Ribble Valley Borough Council
Council Offices
Church Walk,
Clitheroe
Lancashire
BB7 2RA

Phone: 0300 123 6780
Email: developeras@lancashire.gov.uk
Your ref: 3/2025/0889
Our ref: 3/2025/0889/HDC/KW
Date: 02 December 2025

Location: Land at Higher Road Longridge PR3 2YX
Proposal: Erection of a part single-storey and part two-storey dwelling of exceptional design quality (NPPF 84e) with associated landscaping, habitat restoration, change of use of land to residential curtilage and access from higher Road, together with the creation of a small visitor car park for members of the public to view the remains of the Roman road to be preserved within the site.(resubmission of application 3/2025/0095)
Grid Ref: 364169 438922

01003

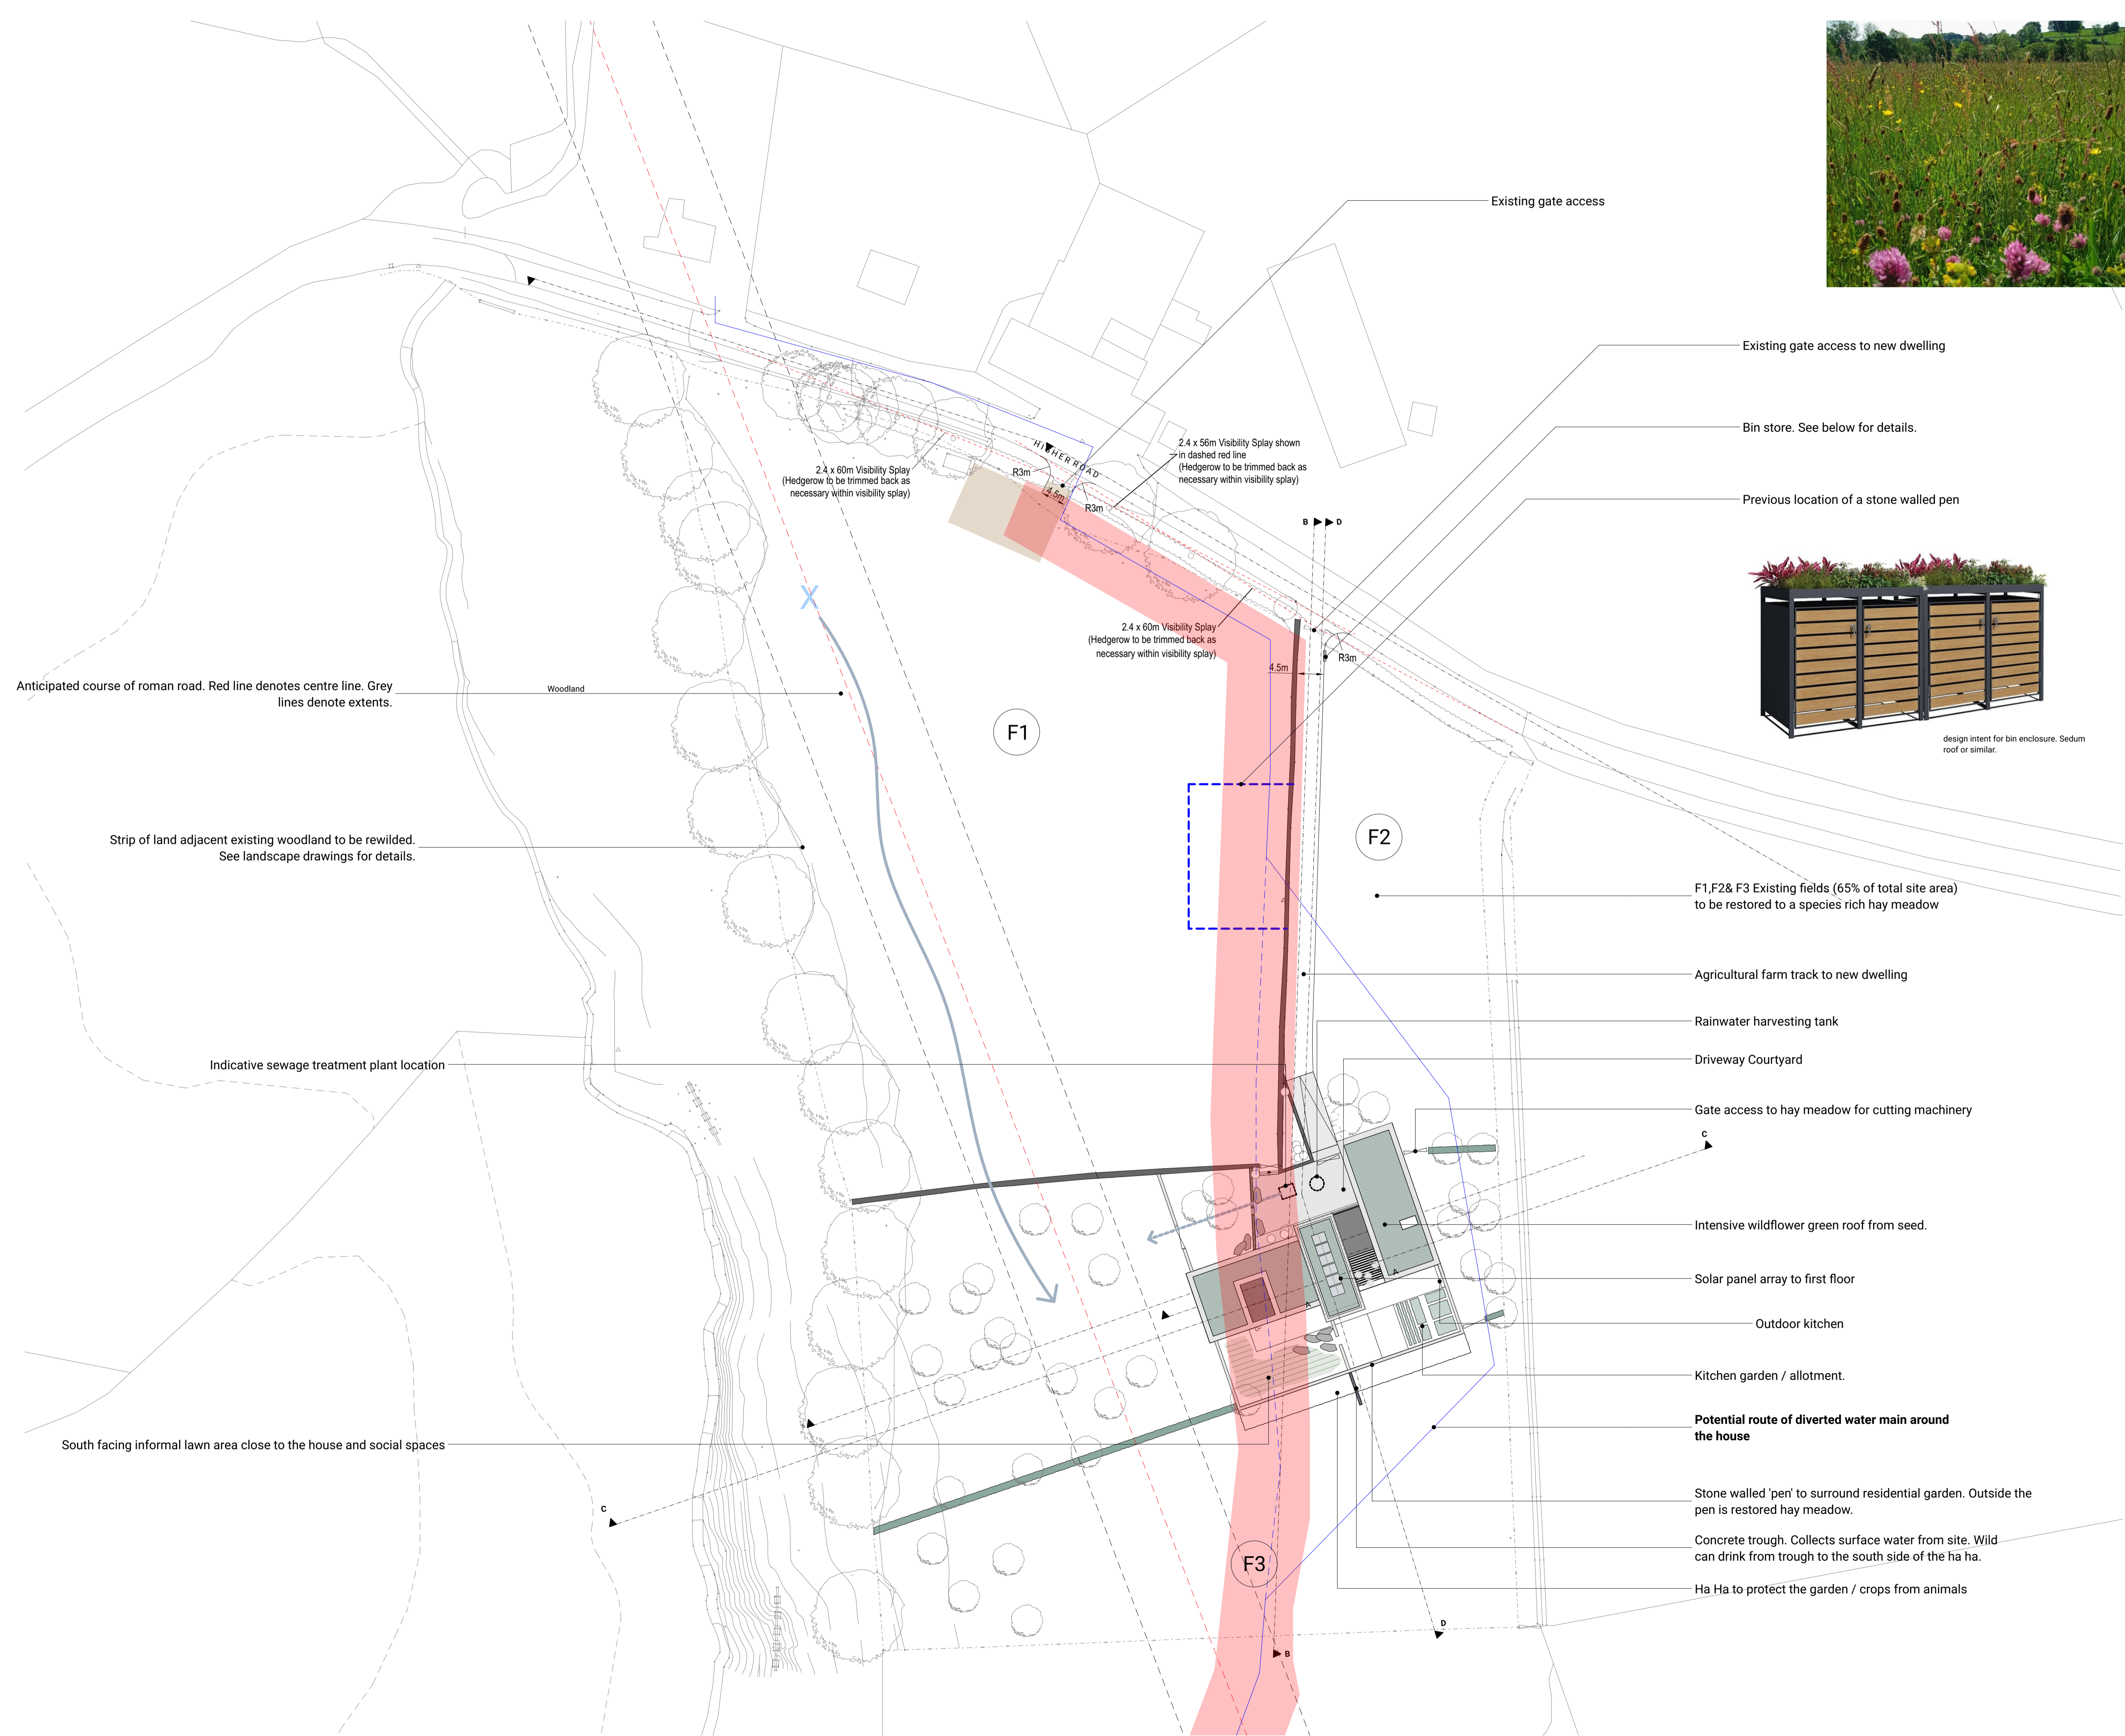
The LHA has reviewed drawing 01003 titled Site Plan as Proposed and would remind the applicant that the access will need to be either ungated or with the gates set back by at least 5m from the edge of the carriageway. The first 5m of both access points will need to be surfaced in a hard standing material and feature drainage to prevent any loose material or surface water from being deposited onto the carriageway. Works within the highway will need to be undertaken under an agreement with Lancashire County Council.

The LHA have reviewed 01003 titled Site Plan as Proposed and are aware that the dwelling complies with the LHAs parking standards as defined in the Joint Lancashire Structure Plan. There is also room to turn within the site allowing for ingress and egress in forward gear.

The proposal features a garage which meets the recommended internal dimensions for a double garage of 6m by 6m and as such can be considered acceptable to provide off street parking provisions. The garage also has additional space to provide secure, covered cycle storage.

The visitor car park is considered sufficient to accommodate 4 vehicles with space to turn to allow all vehicles to enter and leave Higher Lane in forward gear, which is considered necessary. The number of visitors anticipated to visit the site is not presented and is likely unknown therefore we can offer no comment upon the amount of car parking without further information.

4. Prior to first use, that part of the access extending from the highway boundary for a minimum distance of 5m into the site shall be appropriately paved in tarmacadam, concrete, block pavements, or other hard material to be approved by the Local Planning Authority.
Reason: To prevent loose surface material from being carried on to the public highway thus causing a potential source of danger to road users.

6. Before the access is used for vehicular purposes, any gates erected at the access shall be positioned 5m behind the nearside edge of the highway. The gates shall open away from the highway. All gates and associated mechanisms shall be located outside the highway and the gates shall have physical restraints to prevent the gates from opening onto the highway.
